## **FIRE RISK MANAGEMENT, INC.**

# **Memo Report**

**From:** W. Mark Cummings, P.E.  
**To:** Mr. Bill Hopkins; Archetype Architects  
**Subject:** **Fire Protection & Life Safety Review of the Proposed Maine Wharf Museum**

This initial review focused primarily on the proposed renovations for the 2<sup>nd</sup> and 3<sup>rd</sup> floor levels and their potential use as a museum; and specifically evaluating the available means of egress from these upper floors. The primary codes being referenced are NFPA 101 and the IBC/MUBEC. This review was based on the drawings provided by Archetype Architects; dated 05/13/2015.

Date: 5-13-2015
Scale: AS NOTED
**NEW COMMUNICATING
STAIR DETAILS**

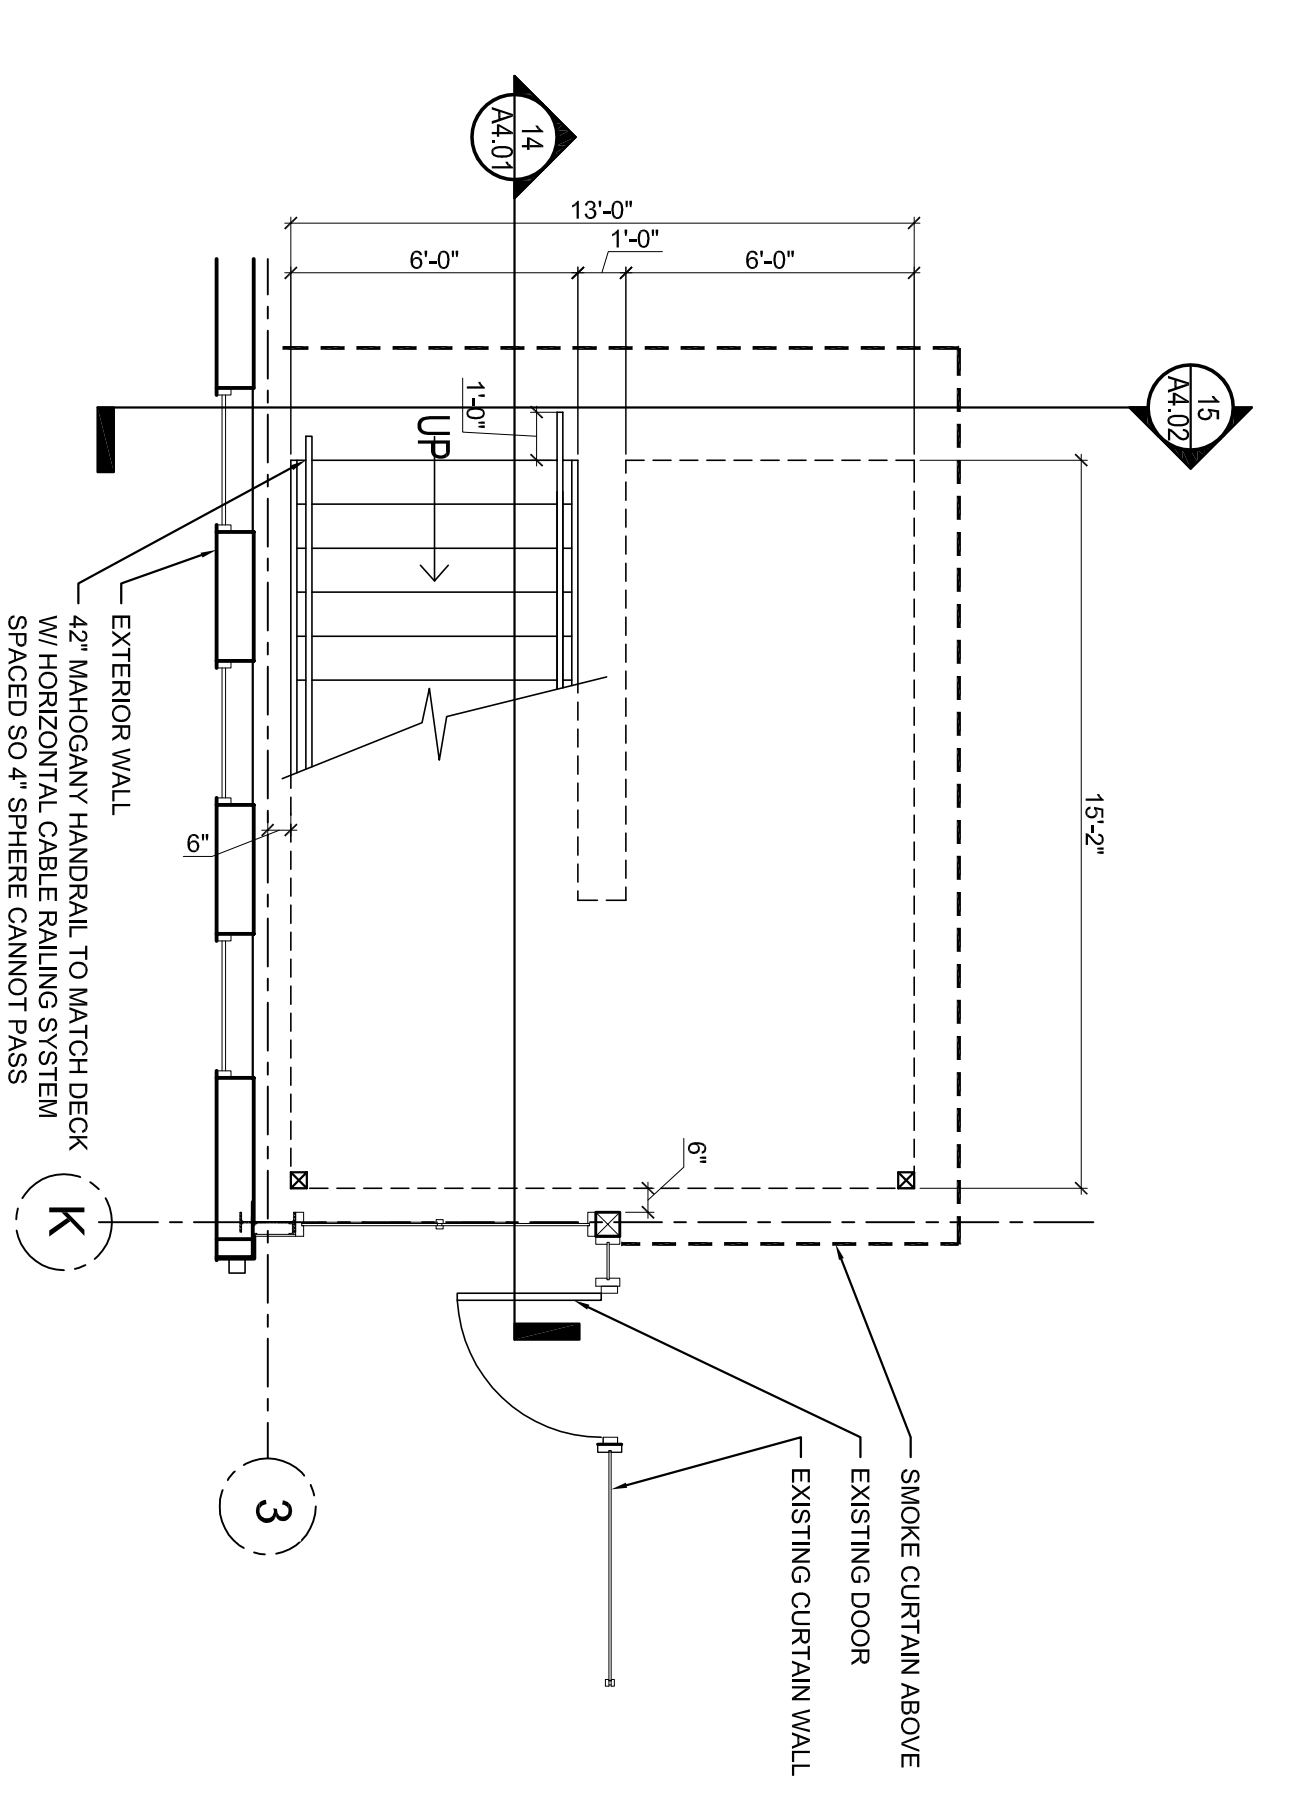
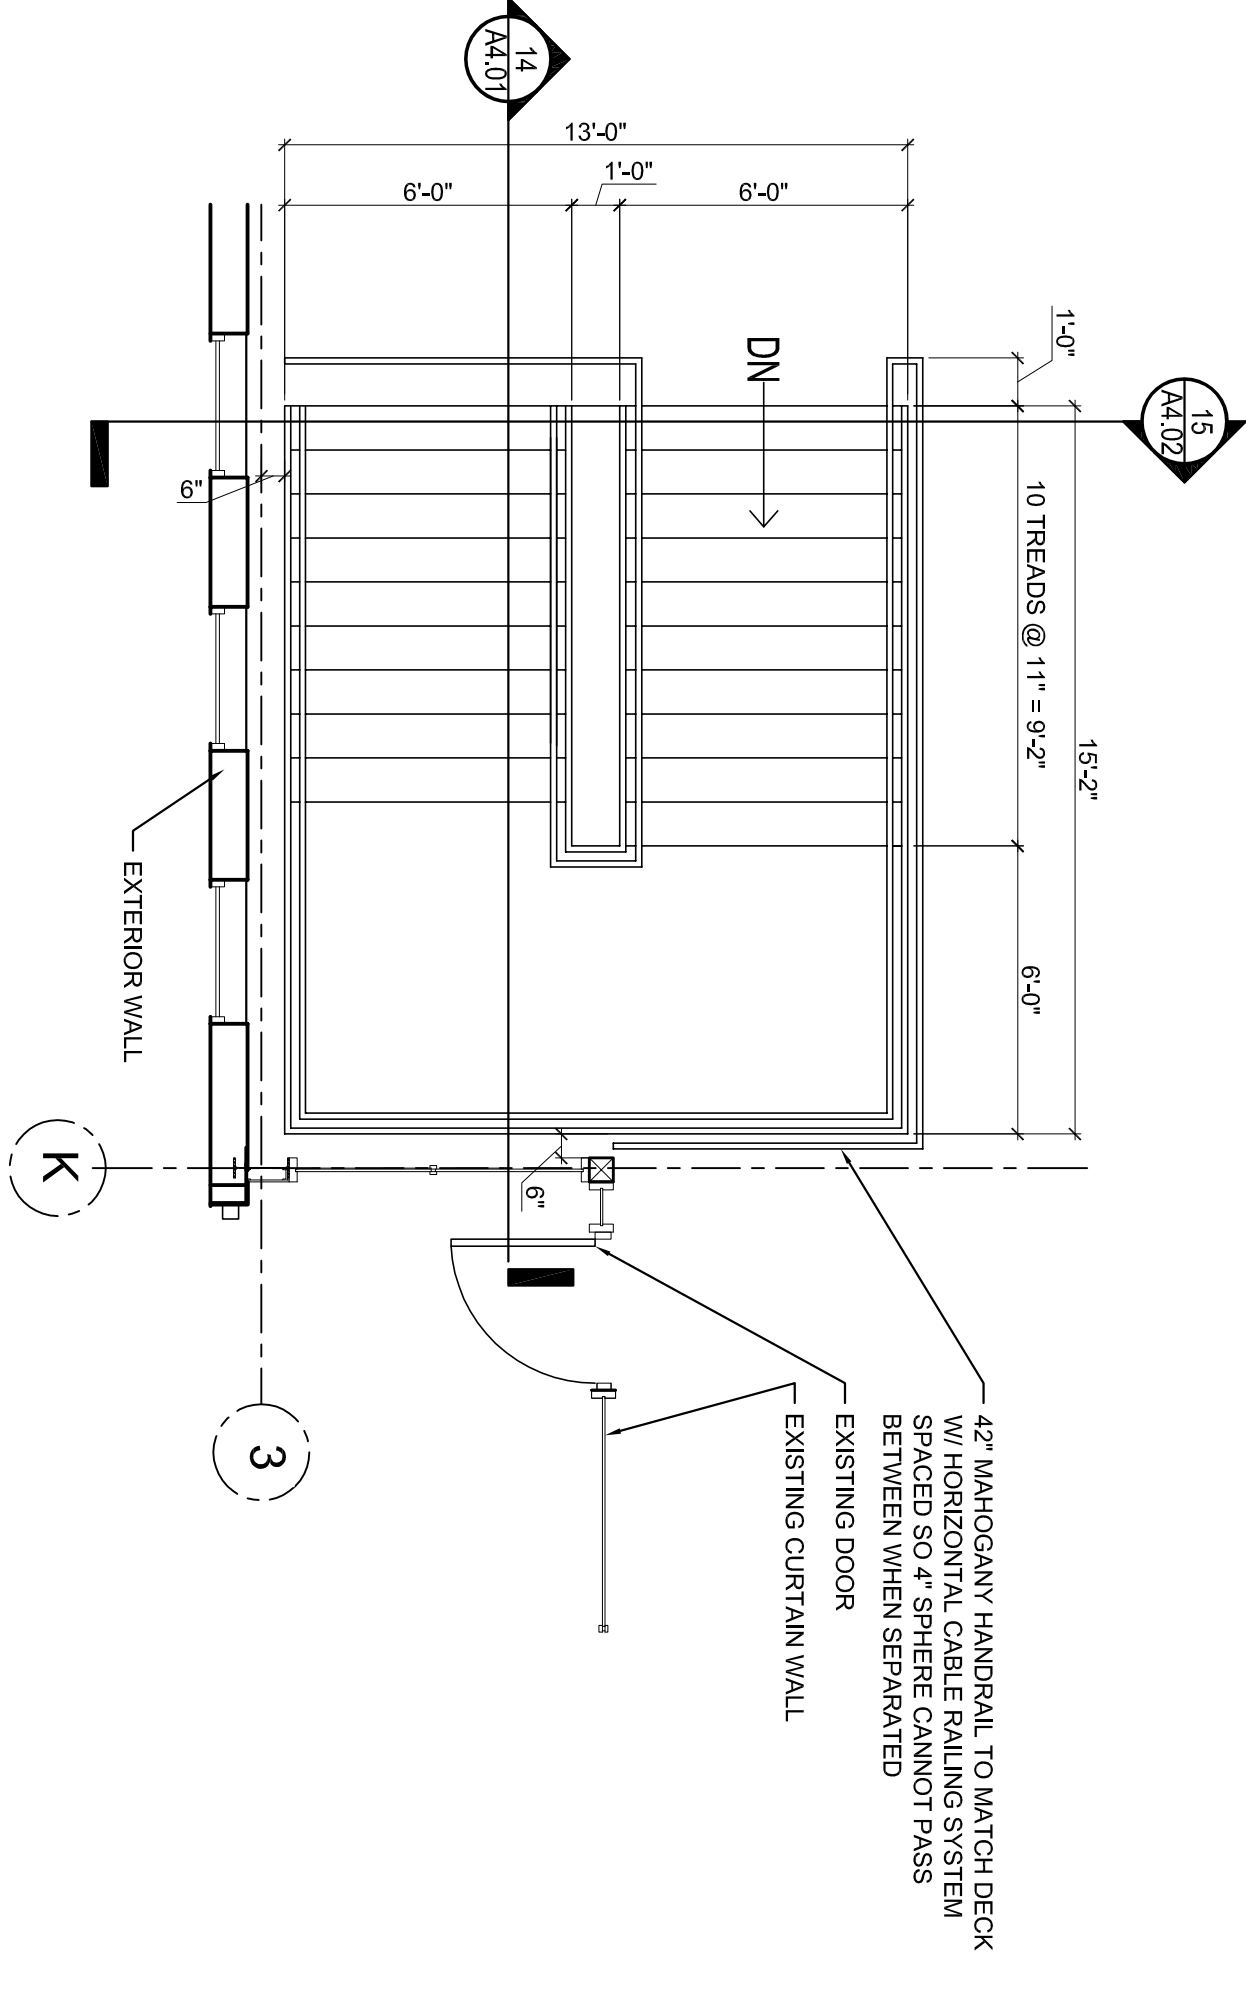
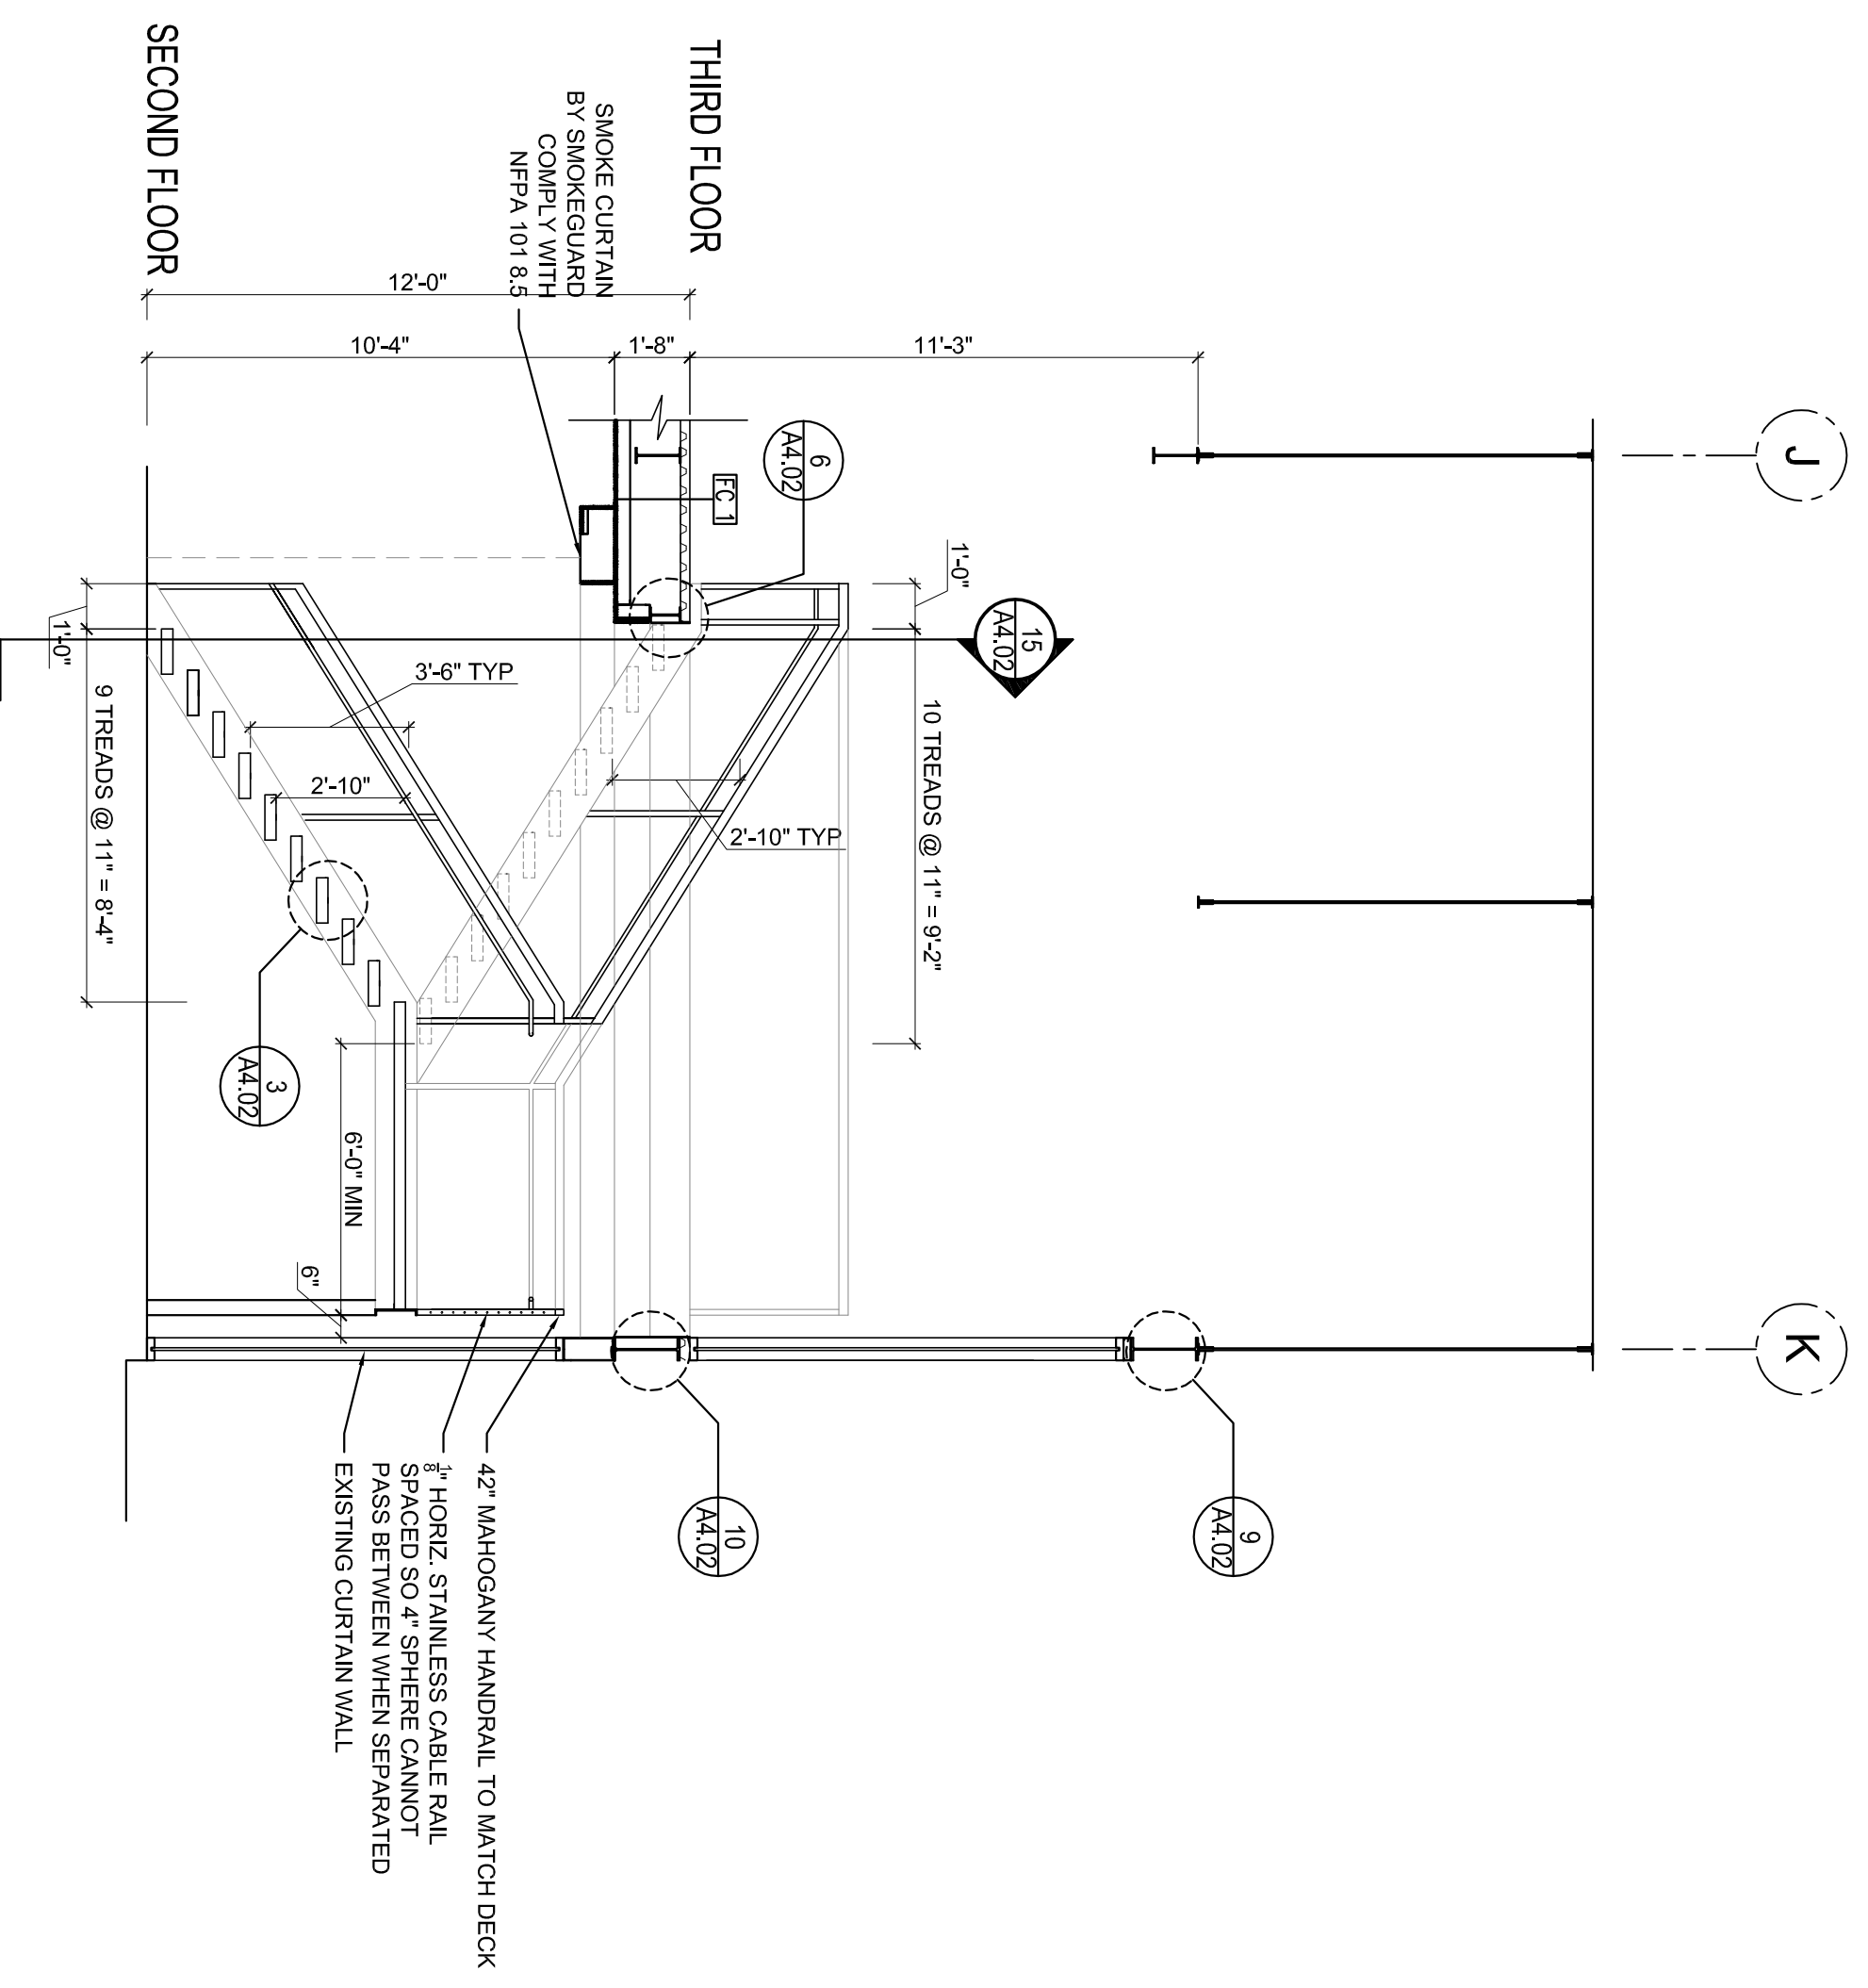
Specifically, the common path of travel distance from the southeast end of each floor will exceed that which is allowed by NFPA 101. Although a new stair is to be included near the southeast corner of the building, this stair only connects the 2<sup>nd</sup> and 3<sup>rd</sup> floor levels and is currently designed as being “open;” effectively meeting the NFPA definition of a “convenience opening” (stair), per section 8.6.8 of NFPA 101. Such openings/stairs are not permitted to be used as part of any required means of egress.

In addition to meeting the Tenant’s requirements regarding the “flow” of people through the museum’s exhibits, it is understood that there is a desire to keep this stairway open to also allow for additional natural lighting within the museum space. However, if this stairway is to be considered as an option to alleviate the lack of compliance for common path of travel, it will need to be isolated from the rest of the building by barriers having a fire resistance rating of at least one hour, or be protected in a manner that has been deemed as providing equivalent protection through the implementation of a performance-based approach and that has been accepted by the Authority(ies) Having Jurisdiction (AHJs); which likely includes the State of Maine’s Fire Marshals Office and the City of Portland’s Fire Prevention Bureau.

A possible option that could be explored for protecting the stairway in the southeast portion of the building, while continuing to meet the Tenant’s requirements/expectations, would be to enclose the stair using walls and doors that incorporate glass panels. The glass could then be protected by modifying the existing sprinkler system, at each level, to include additional sprinklers located around the periphery of the stair enclosure, designed such that all portions of any exposed glass would be subject to direct water application. This is a method that is routinely used to protect glass walls/panels that form barriers of atriums. If it is also desired that the doors that provide access to this stairway remain open at all times other than in an emergency, magnetic hold-open devices could be installed that are operated by the fire detection/alarm system; via actuation of adjacent smoke detectors as outlined in NFPA 72.

Based on the initial review of the plans provided for the proposed renovations to the 2<sup>nd</sup> and 3<sup>rd</sup> floors of the Maine Wharf building, it will be necessary to take steps to alleviate the excessive length of the common path of travel distance from the southeast end of the building. Without making major structural changes to the building itself, beyond that which is already planned, the most viable option to correct this code deficiency appears to be providing separation for the stairway connecting the 2<sup>nd</sup> and 3<sup>rd</sup> floor levels in this area of the building. Based on discussions regarding the Tenant’s requirements for the museum, it is recommended that consideration be given to separating this stairway from the remainder of the building, using an alternative approach that is designed to provide an equivalent level of protection to that which would be afforded if “standard” fire rated assemblies were used. It is believed this can be achieved through the use of glass, or partial glass, walls and doors that are specifically protected using the installed fire sprinkler system. Equally, automatic closing doors controlled by the fire alarm system could also be used to allow the uninterrupted flow along these stairs during normal operations. However, any such approach will need to be approved by the AHJ(s); and such approval should be obtained prior to moving forward with any efforts along these lines to ensure they are, in fact, willing to consider a performance-based alternative.
